COMMUNITY SERVICES DEPARTMENT

May 25, 2022

Subject: Grandview Reserve Filing No. 1 PUD Preliminary Plan, Review #3 – (PUDSP-21-010)

#	Date	Issue / Description	Init.
1			
2			
3			
4			
5			
6			
7			
8			
9			
10			
11			
12			
13			
14			
15			
16			
17			
18			
19			
20

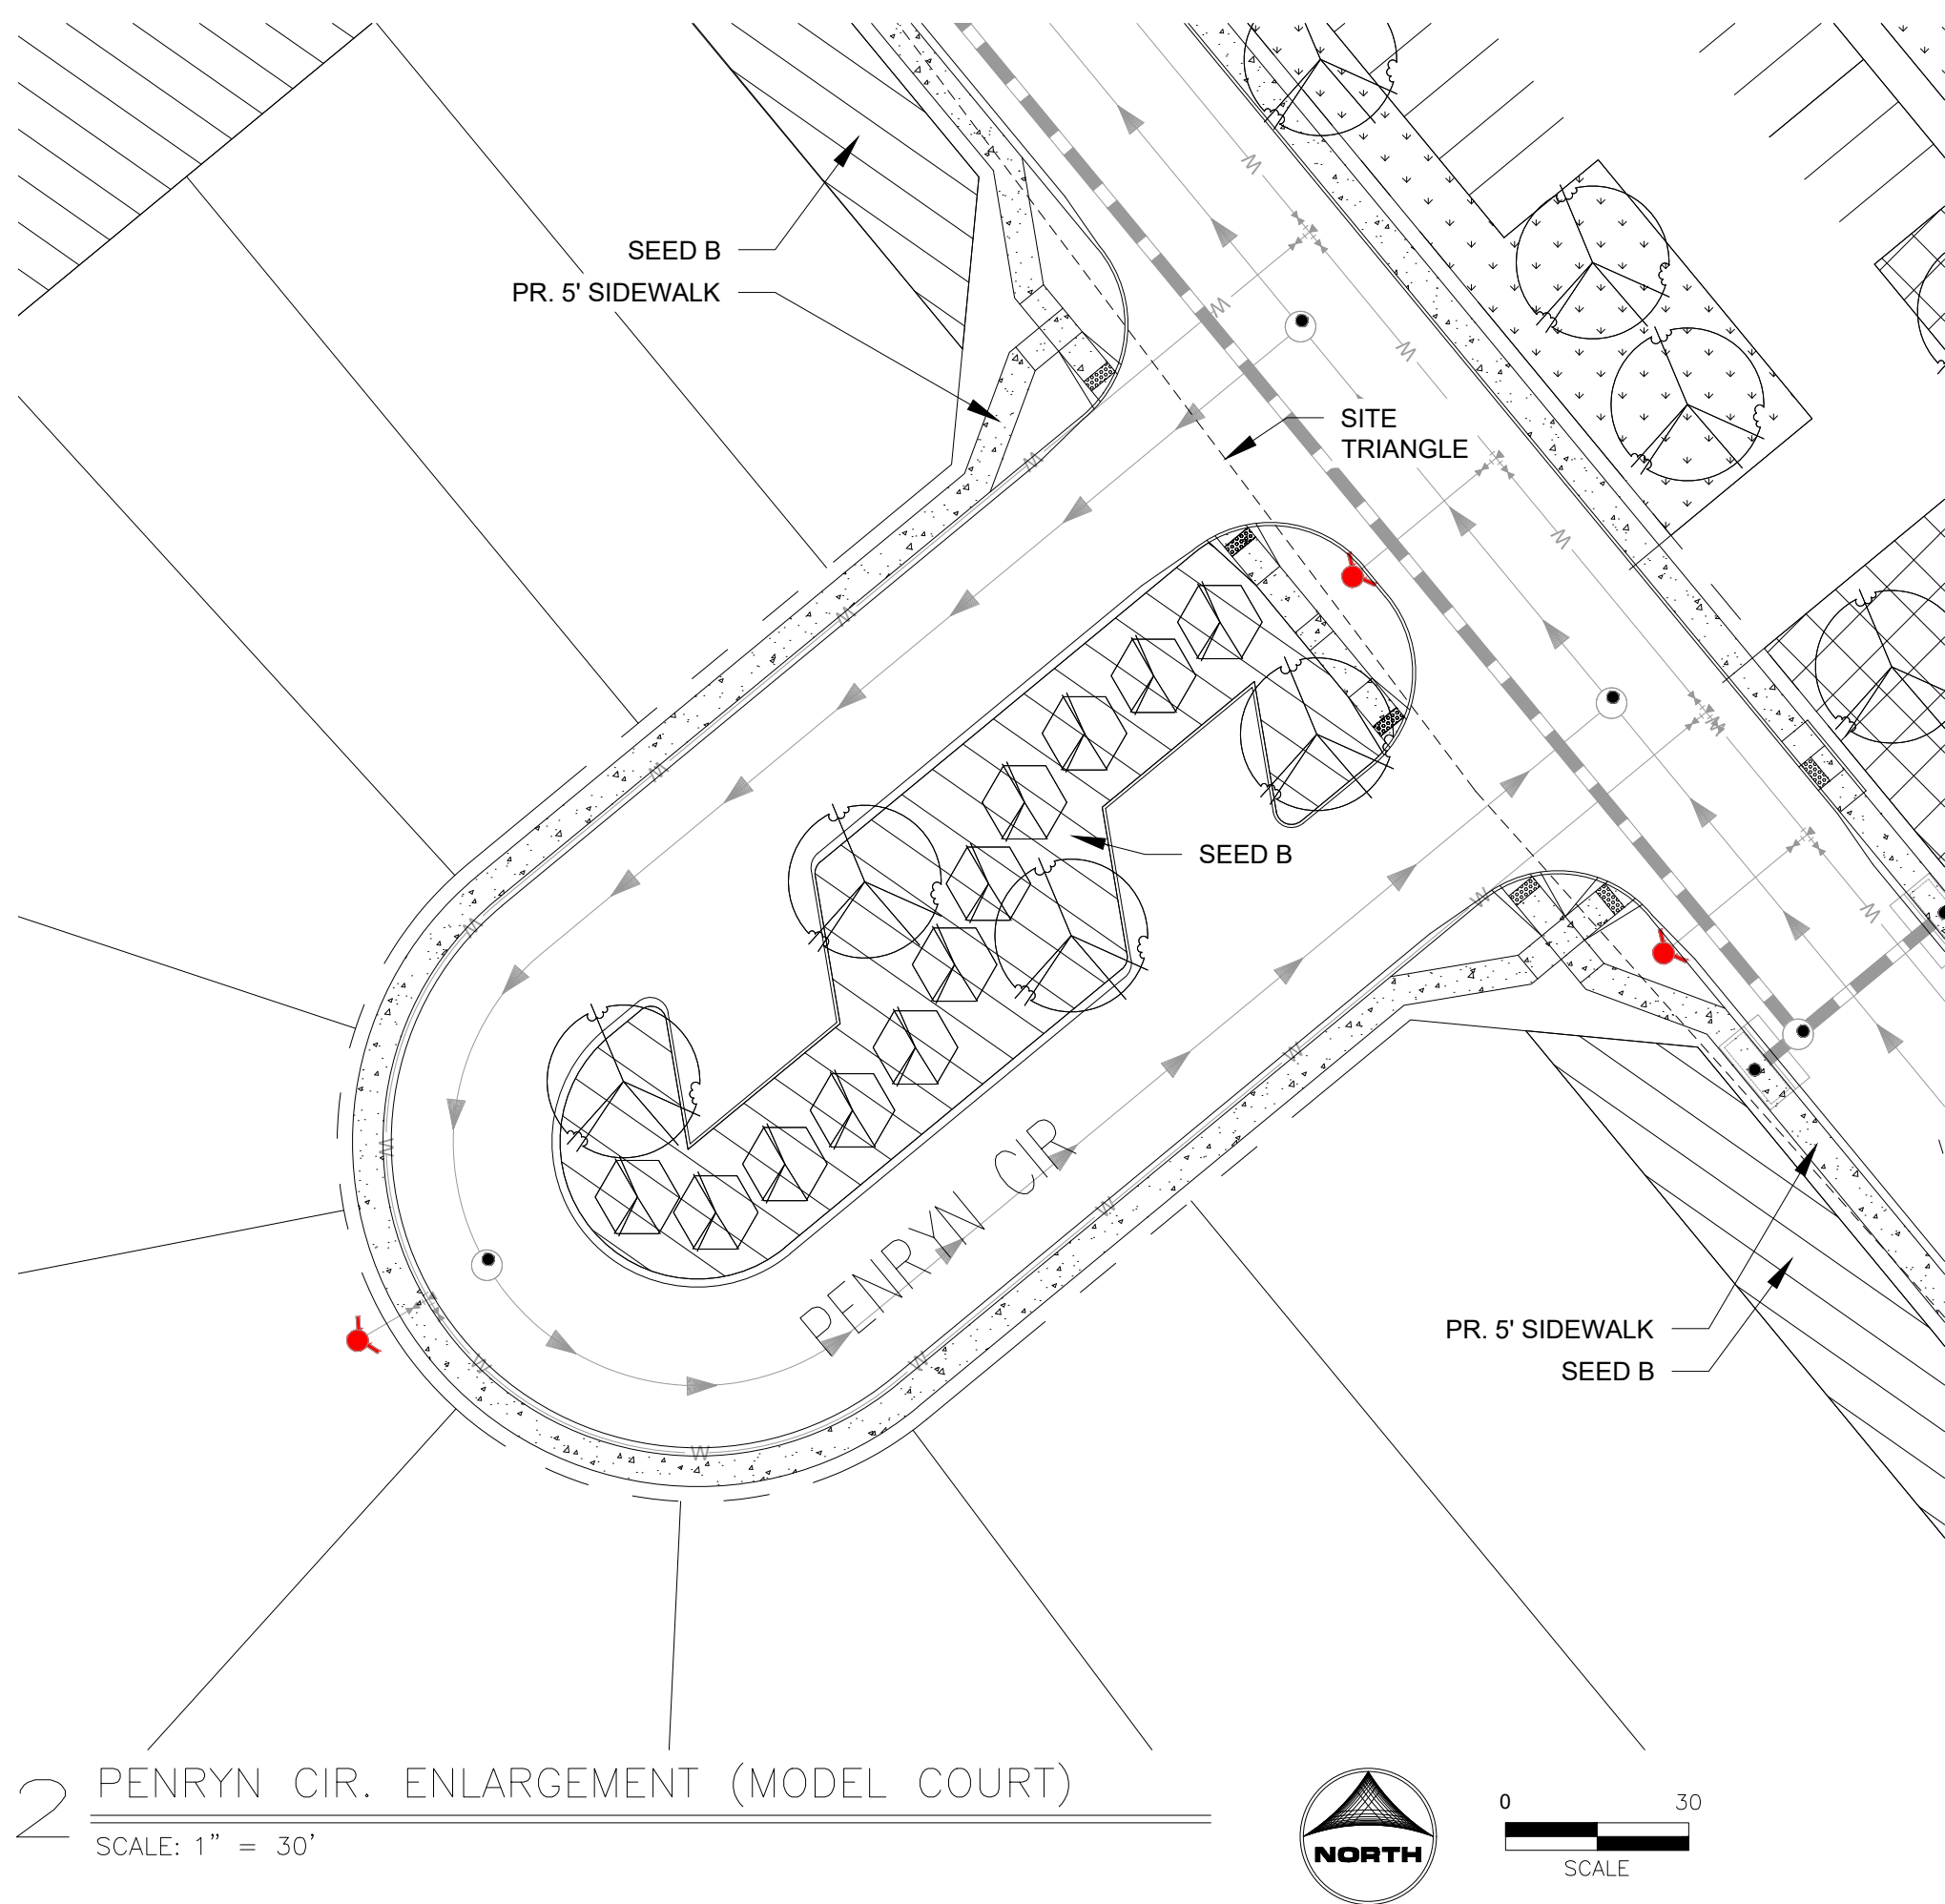
"Staff acknowledges and appreciates the inclusion of the detailed Amenity Center plans and Eastonville Primary Regional Trail easement as part of the Landscape Plans. Staff recommends that the trail easement be included and labeled in the PUD Development and Preliminary Plans, as is the case with other utility easements and right-of-ways along Eastonville Road. Please note the inclusion of an updated parks, trails, and open space map in this packet, which includes updated trails that have been revised as part of the ongoing 2022 El Paso County Parks Master Plan process."

Moreover, staff recommends that the applicant submit detailed site plans for the proposed Amenity Center, as the currently proposed neighborhood pocket park does not include multi-generational recreational amenities such as a playground, multi-use turf field, or seating and picnic areas. The submitted Landscape Plans only show landscaping and a connecting pathway within the proposed pocket park.
